TOWN AND COUNTRY PLANNING ACT 1990 NON MATERIAL AMENDMENT

Reference: H08-1031-25 **Date of Decision:** 31st October 2025
Applicant: R K Wilson Builders Ltd.
C/O Robert Doughty Consultancy Limited
32 High Street
Helpringham
Sleaford
NG34 0RA
Location: Riseholme Farm Windmill Lane Gosberton Risegate Spalding
Description: Erection of 6 single storey dwellings and garages, formation of parking and bin collection point and reinstatement of existing access - approved under H08-0282-24. Amendments to foundation design to that required under Condition 3 of approval H08-0282-24

South Holland District Council hereby give notice that this application has been REFUSED in respect of the non-material amendments referred to above for the following reason(s):

| TITLE<br>PROPOSED STRIP FOUNDATION ARRANGEMENT<br>& SECTIONS - PLOT 3                                                          |                                                           |              |              |          |  |

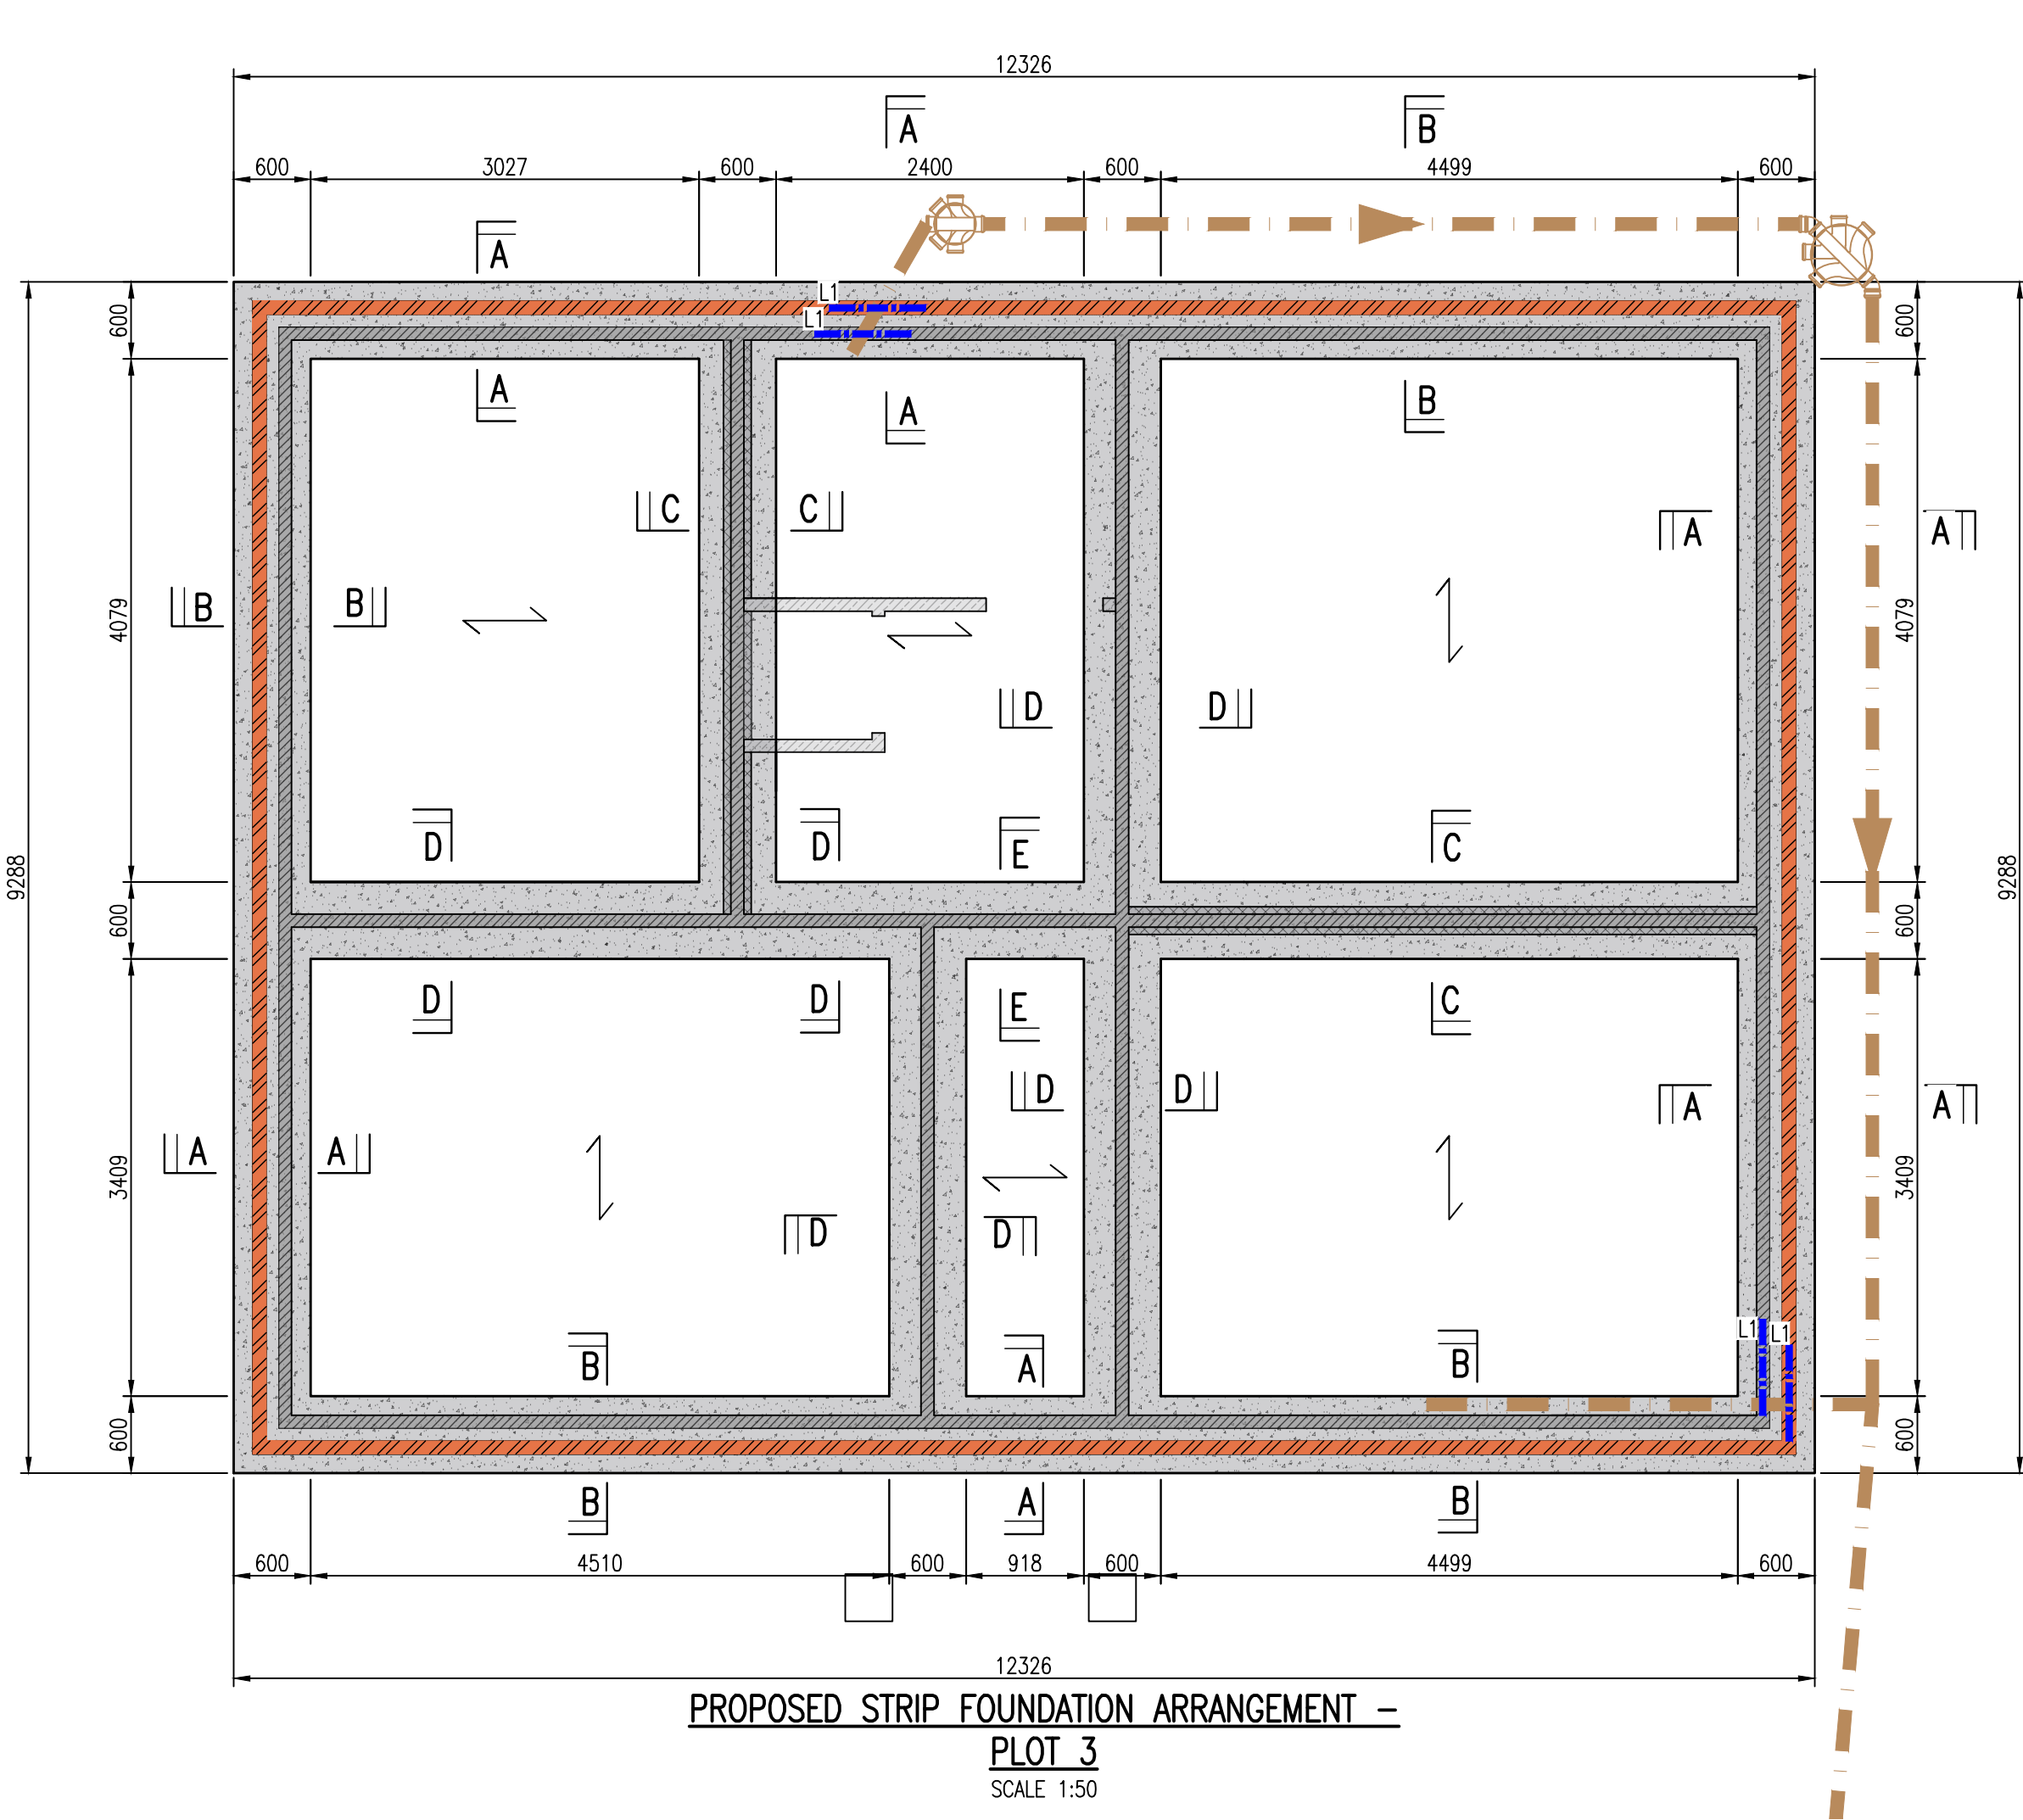
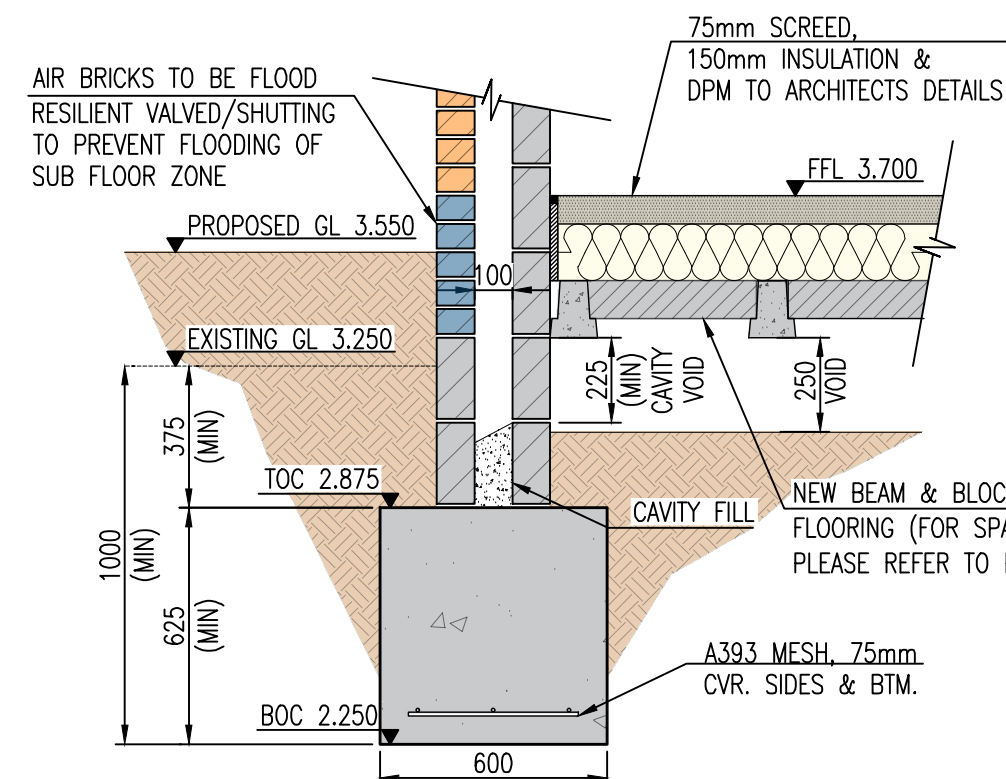
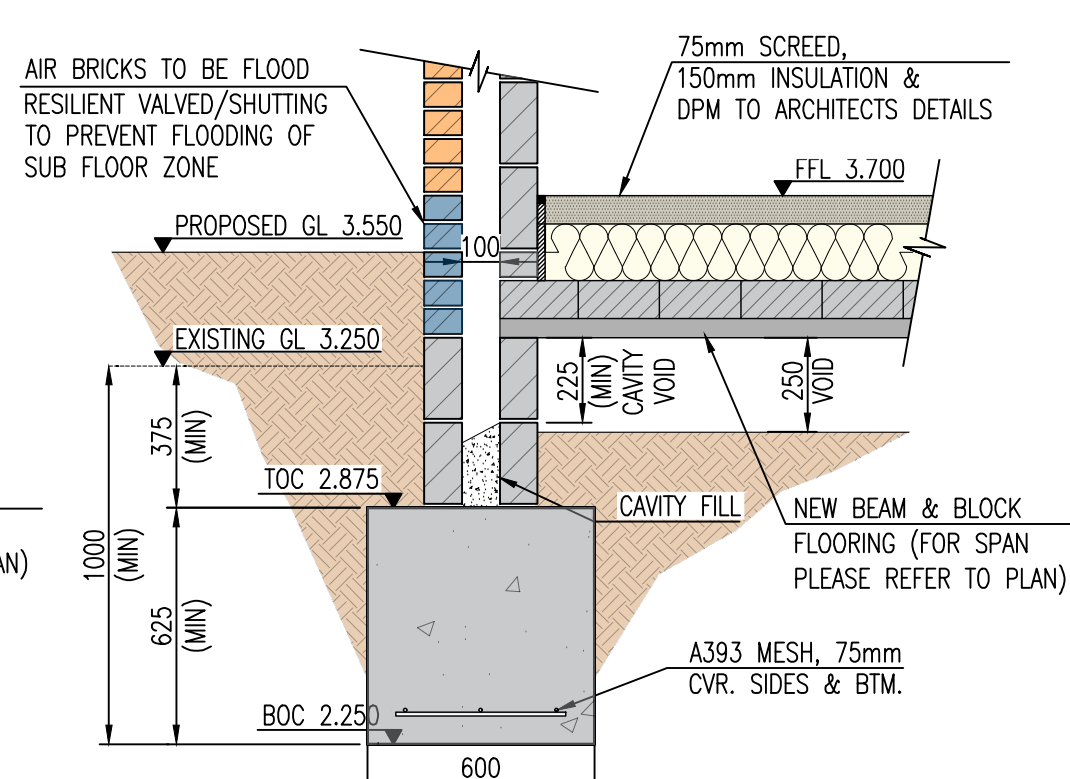
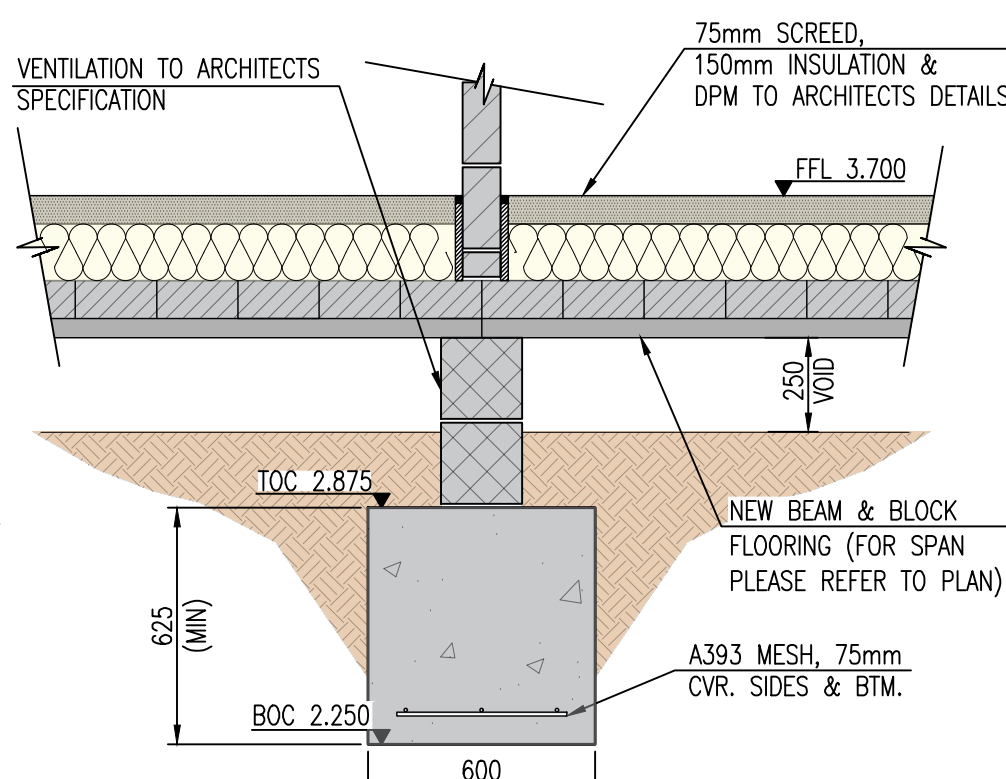
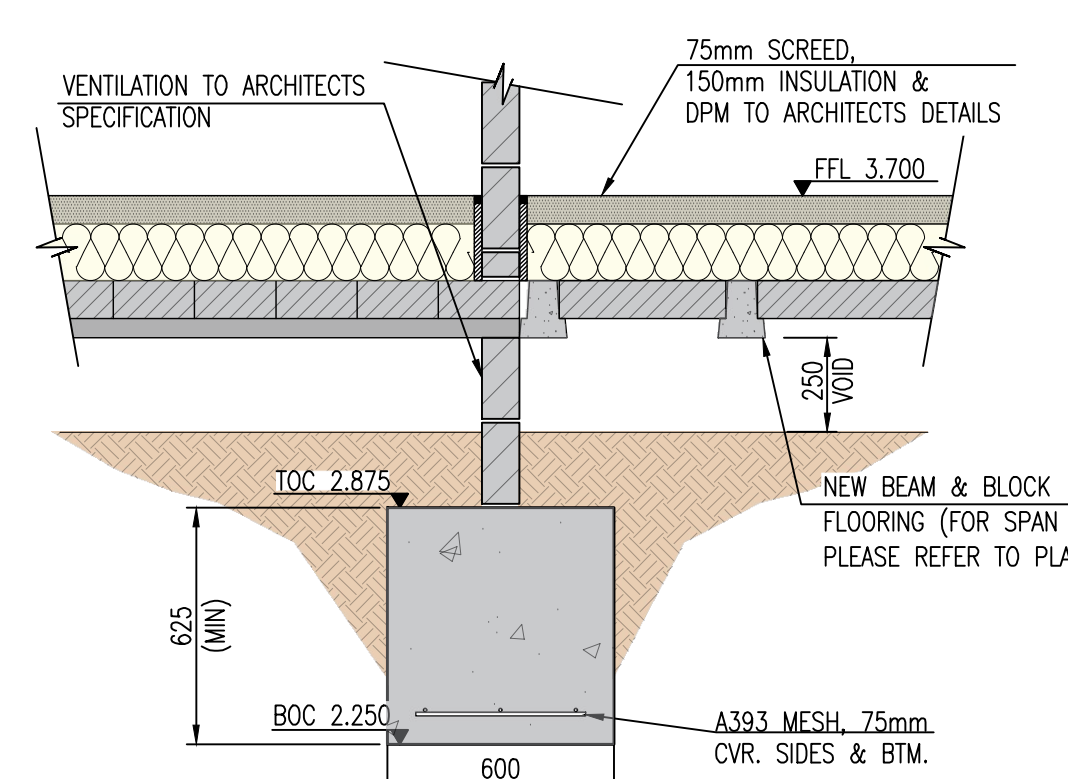
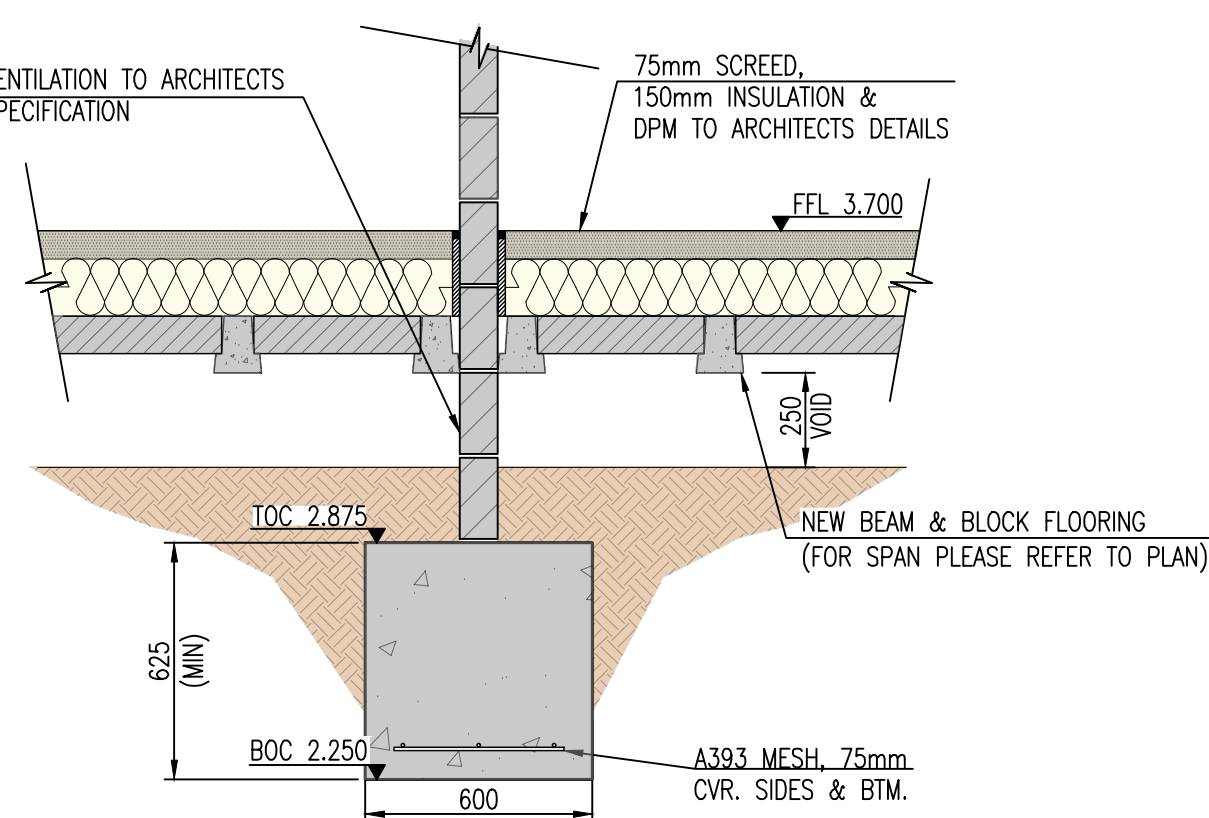
- 1 Point 8 of South Holland District Council's guidance on non-material amendments confirms that such amendments must not result in a fundamental change to the design of the approved building. The approved Flood Risk Assessment (FRA) by RM Associates establishes a critical flood resilience requirement that "the ground floor shall be constructed with a solid concrete floor with no voids beneath and no low-level wall vents." The proposed introduction of a strip foundation incorporating voids beneath the floor would fundamentally alter this key element of the approved design and directly conflict with the flood mitigation measures integral to the scheme's acceptability.

Accordingly, the amendment would constitute a material change to the approved development and cannot be treated as a non-material amendment under Section 96A of the Town and Country Planning Act 1990 (as amended).
